**KIRKLEES METROPOLITAN COUNCIL
INVESTMENT & REGENERATION SERVICE**

DELEGATED DECISION TO DETERMINE PLANNING APPLICATIONS

Reference No: 2019/62/92734/E
Site Address: 9, Chapel Fold, Staincliffe, Batley, WF17 7AY
Description: Erection of extensions and dormer windows to front
Recommending Officer: Jennifer Booth

DECISION - REFUSE

side

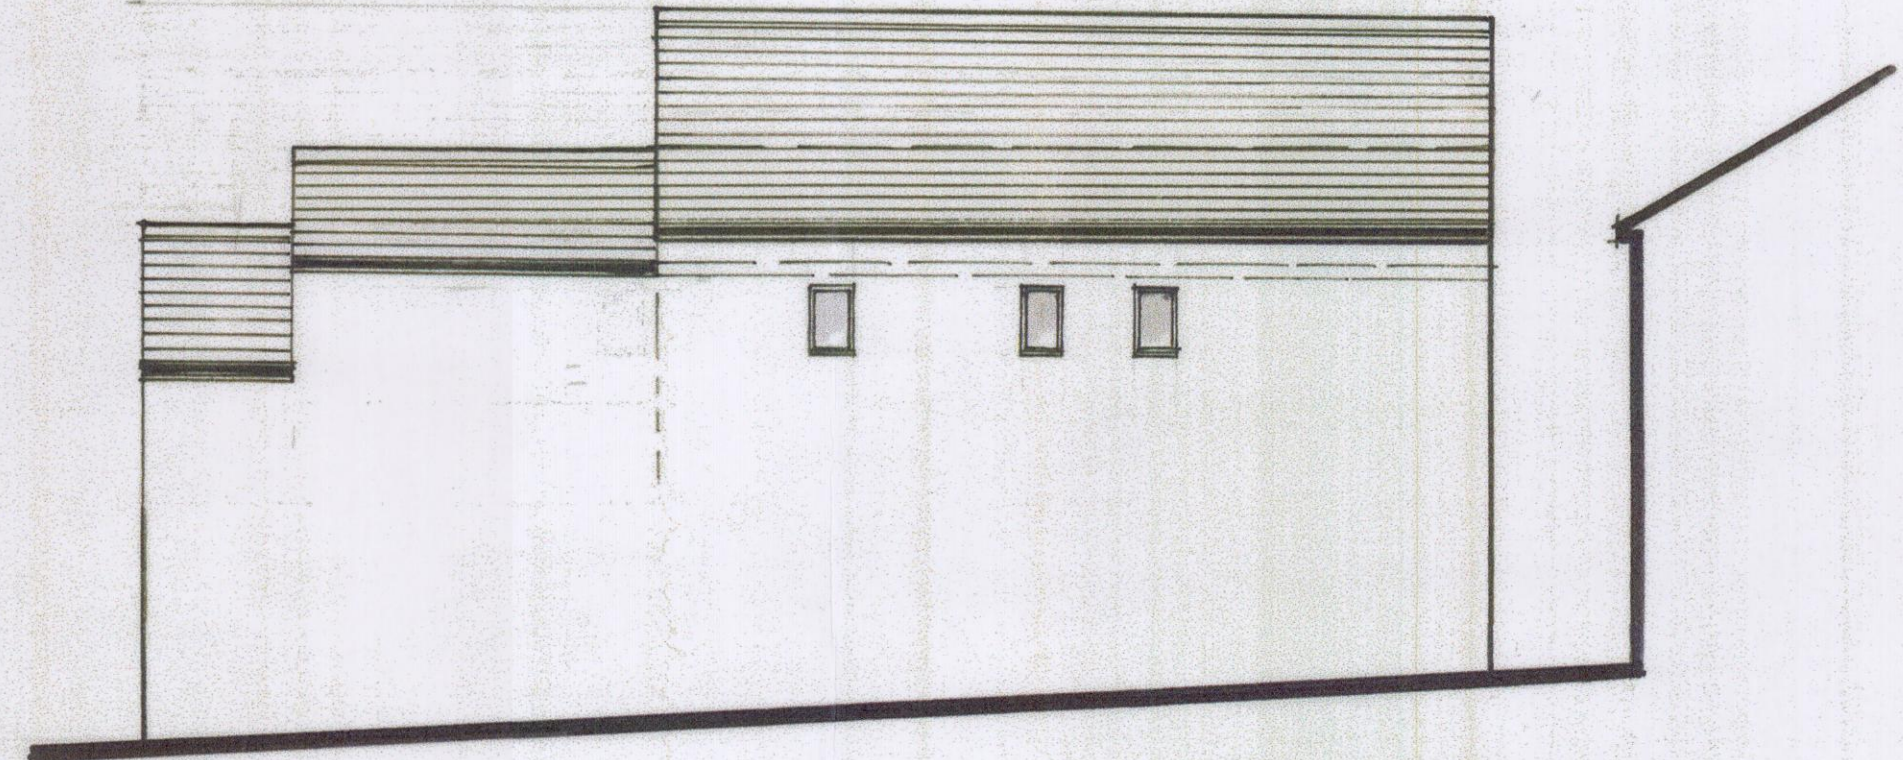
Members considered the surrounding area and acknowledged that there was a mix of house types however, when considered with the immediate surrounding context, they considered that the bulk, height and massing of the extensions proposed (both above the main house and above the garage) would be too large and appear out of context with the immediate neighbours. They considered that this would be out of keeping with the properties next door and the character of the immediate area, contrary to policy LP24 (c) of the KLP.

In addition, members also confirmed that they had significant concerns regarding the impact on residential amenity as a result of the overall bulk and massing of the extensions and the very close relationship with the neighbouring property to the rear, no. 15 Chapel Fold. They considered that this would result in an unacceptable level of overbearing impact, once again contrary to Policy LP24 (c) of the KLP.

1. The proposed extensions, by reason of their bulk, height and massing would result in the formation of an incongruous development that would be significantly harmful to the character of the immediate area. To permit the proposals, which would not promote good design, would be contrary to Policy LP24 (c) of the Kirklees Local Plan as well as the aims of Chapter 12 of the National Planning Policy Framework.

2. The proposed extensions, by virtue of their resultant bulk and massing, together with the close proximity to the neighbouring property to the rear (no.15 Chapel Fold), would result in significant harm in terms of an overbearing impact on the residential amenity of the occupiers of this neighbouring property. To permit the proposals, which would not promote good design, would be contrary to Policy LP24 (c) of the Kirklees Local Plan.
